The Planning Inspectorate Yr Arolygiaeth Gynllunio

Our Ref: EN010069

Date: 6 March 2015

Further to your email of 30 January 2015, please find attached to this letter the Planning Inspectorate's comments on the draft documents submitted for the Abergelli Power Project as follows:

2.2 Land Plans

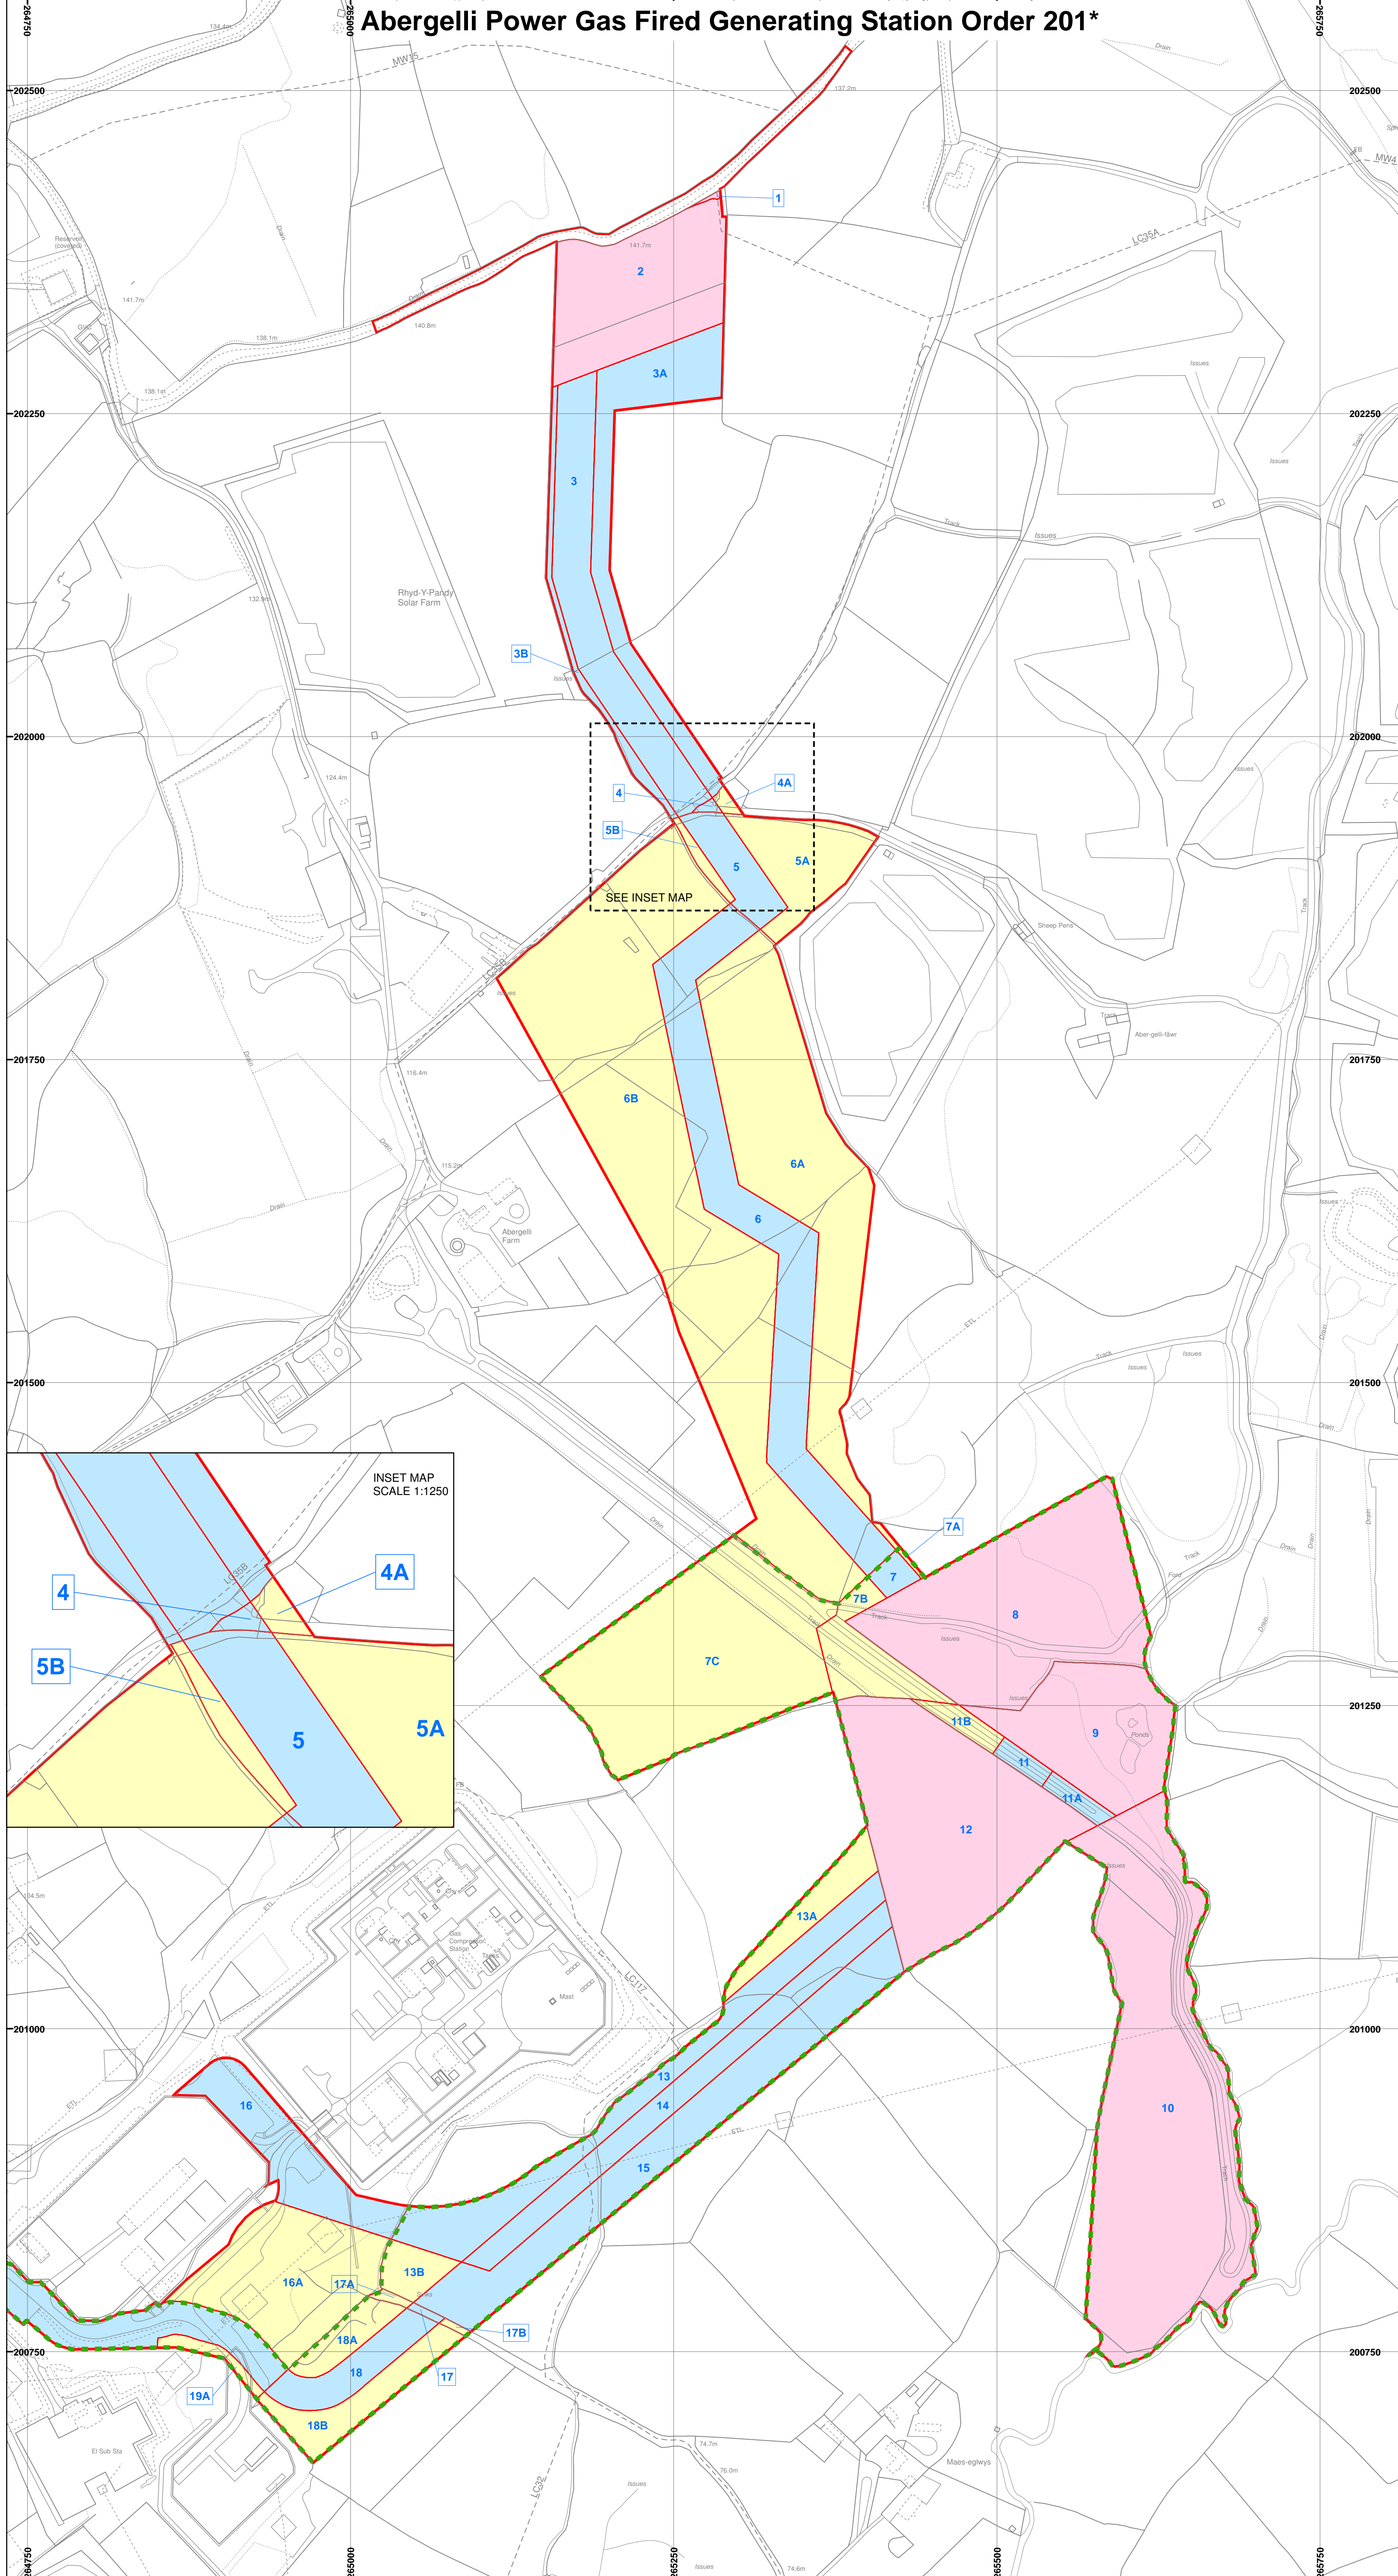
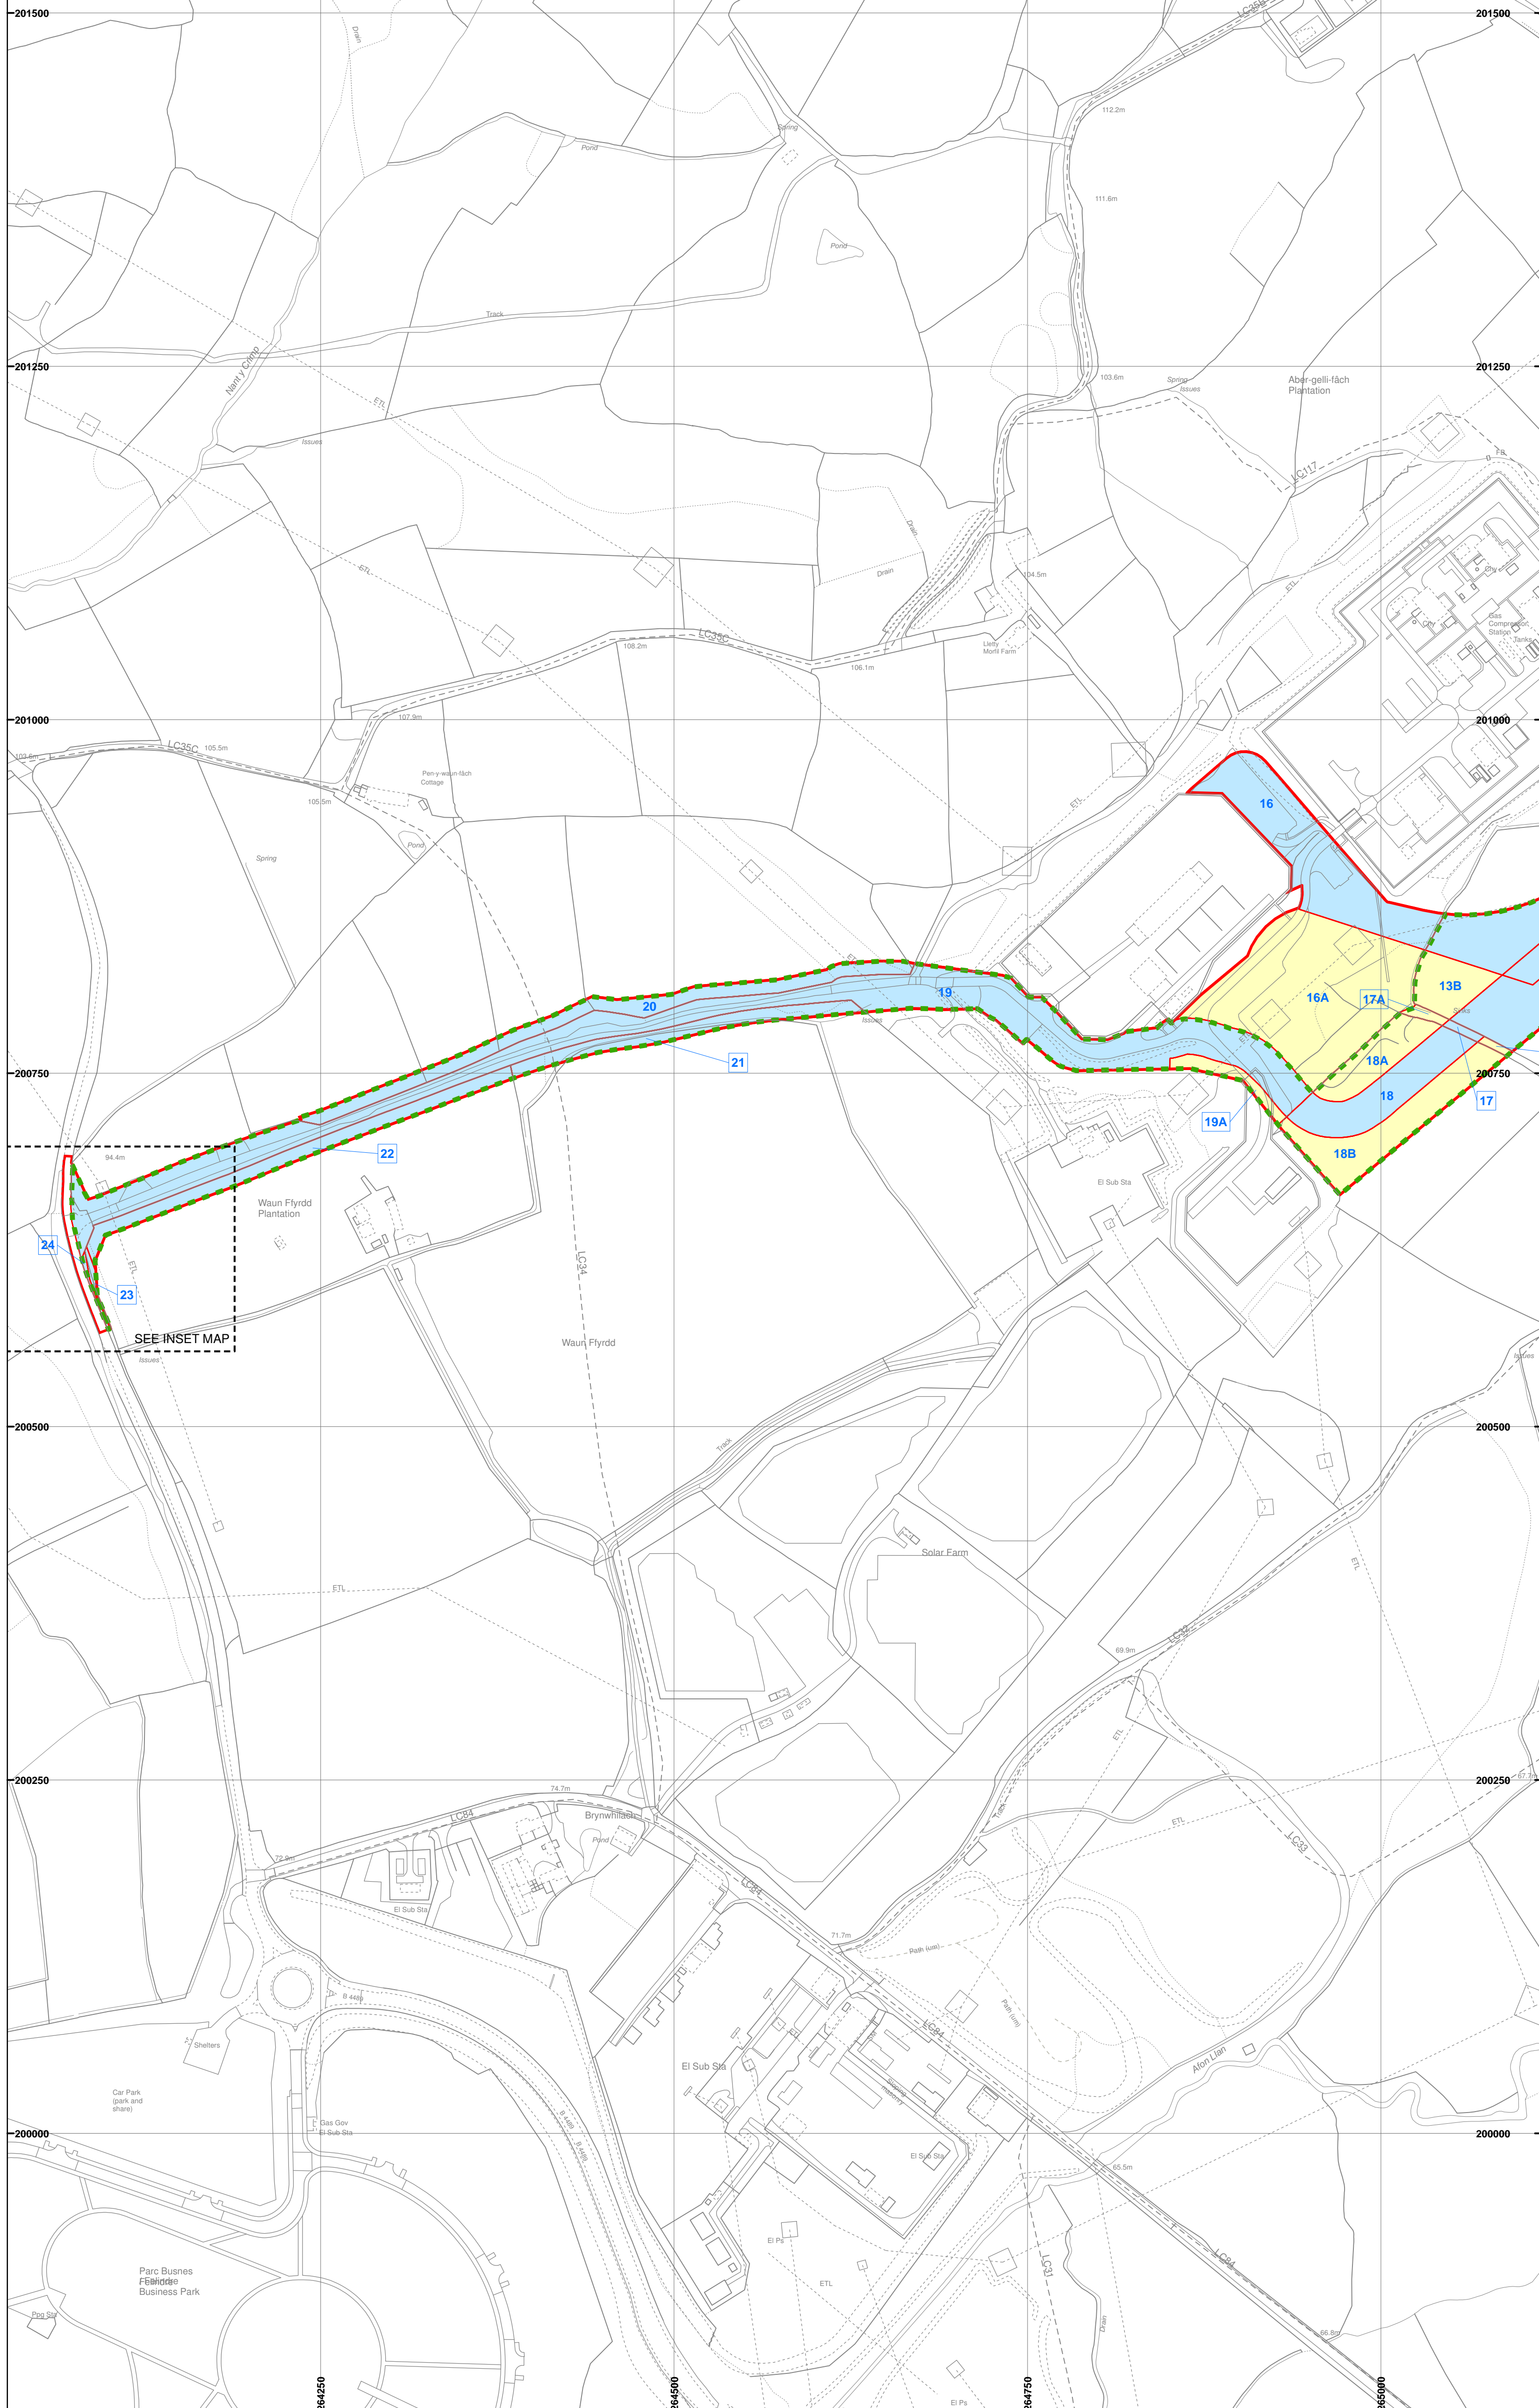
1. Revised Development Consent Order
2. Explanatory Memorandum
3. Revised Consultation Report
4. Work Plans
5. Land Plans
6. Book of Reference
7. Funding Statement

- There is a large degree of flexibility sought with respect to the design of the generating station and the application needs to clearly establish what the applicant is seeking consent for;
- There is no scope for associated development in Wales under the PA 2008 consenting regime, therefore the case must be clear that all works applied for form part of a nationally significant infrastructure project;
